## **PLANNING APPLICATION Reference 6/2020/1344/FULL**

### **COMMENTS BY THE NORTH MYMMS DISTRICT GREEN BELT SOCIETY**

**July 2020**

Drawing Name
Existing Site Location Plan + Photos

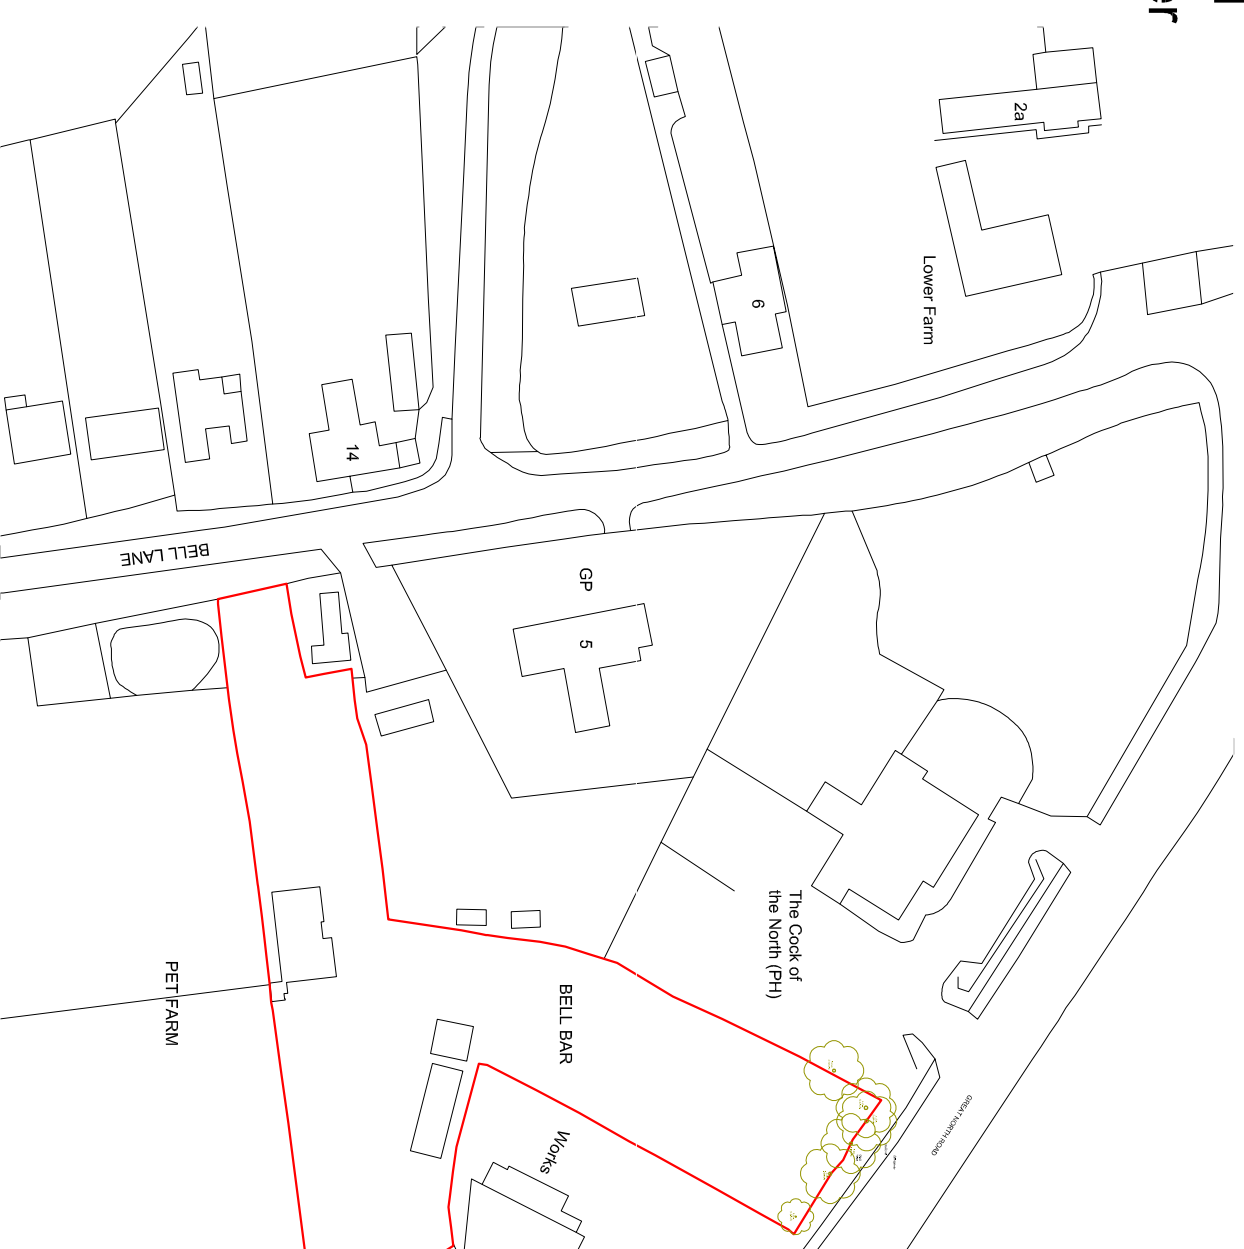
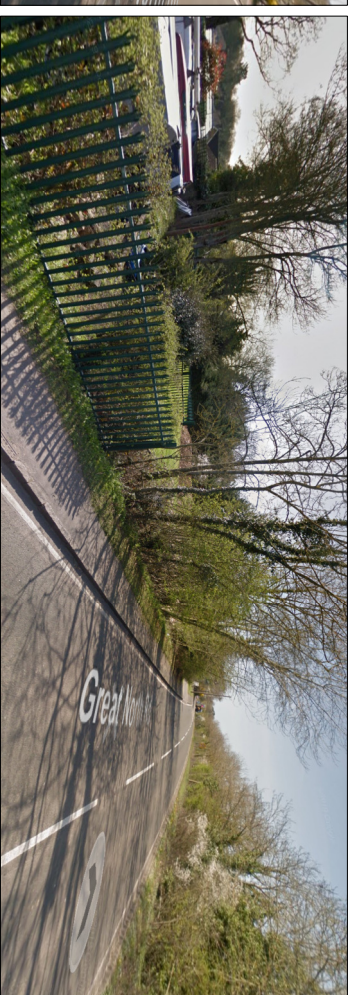
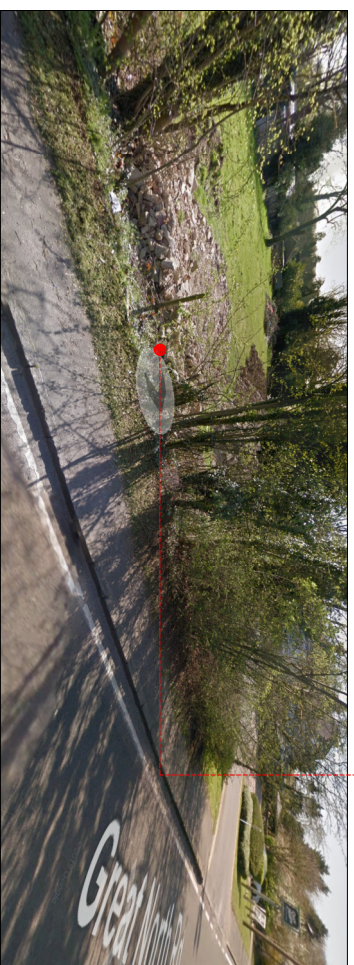
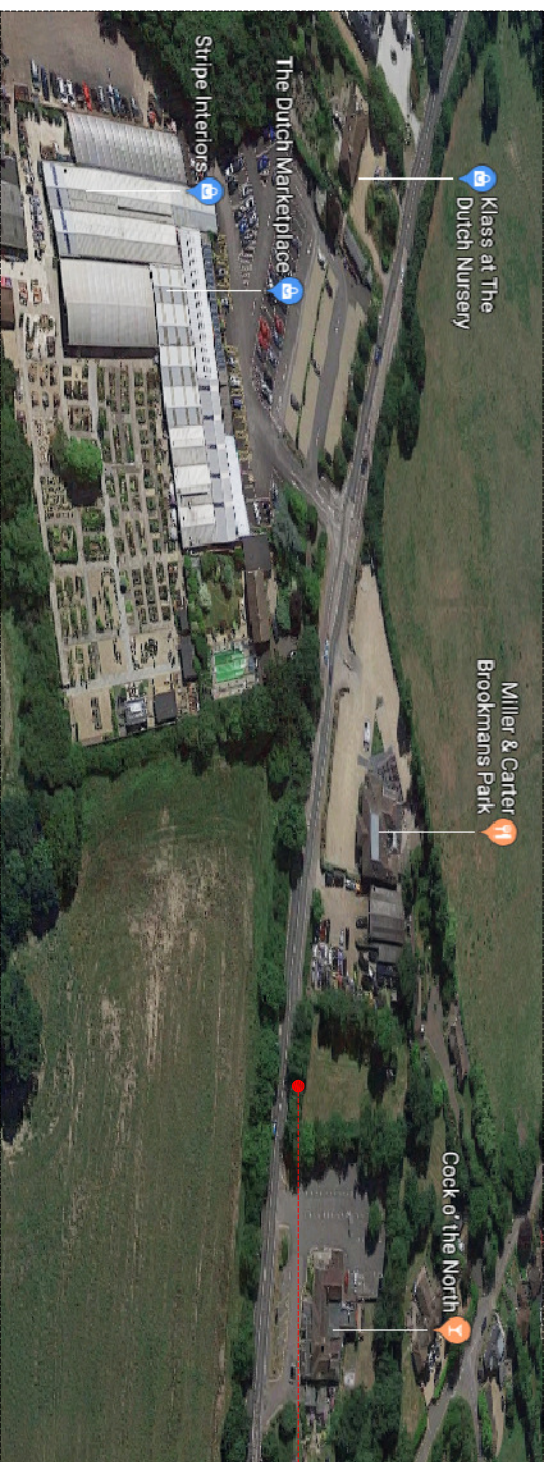
3. Although no detailed alignment is shown, the proposed driveway would cross the open amenity land which forms most of the site. In the view of the Society, this would have a harmful effect on the openness of the Green Belt in this sensitive location, contrary to paragraph 144 of the National Planning Policy Framework, where no very special circumstances have been demonstrated for its development. It is also contrary to Policy GBSP2 of the Welwyn Hatfield District Plan 2005.

5. As shown in the submitted plans and the accompanying photographs, the proposed access is linked directly to the A1000, which is particularly busy through Bell Bar. Despite a speed limit, there are dangers from fast-moving traffic and conflict at a number of site entrances. The proposed access is at a potentially dangerous location, less than 50 metres from the entrance to the car park at the Cock O' the North public house. To the south, there is another busy access to the Miller and Carter Steak House, which has recently been extended. Further to the east is the access to the Dutch Nursery and Garden Centre, also connected to the A1000. In addition, to the north of the site, there is the complex junction between the A1000, Bell Lane, and Woodside Lane.

6. Taken together, it is clear that a new access in the proposed should not be countenanced in terms of highways policy. The Pet Farm has a satisfactory existing access to Bell Lane, which is a quiet road, with is much safer. In the view of the Society, therefore, the application should be refused in there would be an unacceptable impact on highway safety, contrary to paragraph 109 of the National Planning Policy Framework and the Hertfordshire Local Transport Plan (LTP4).
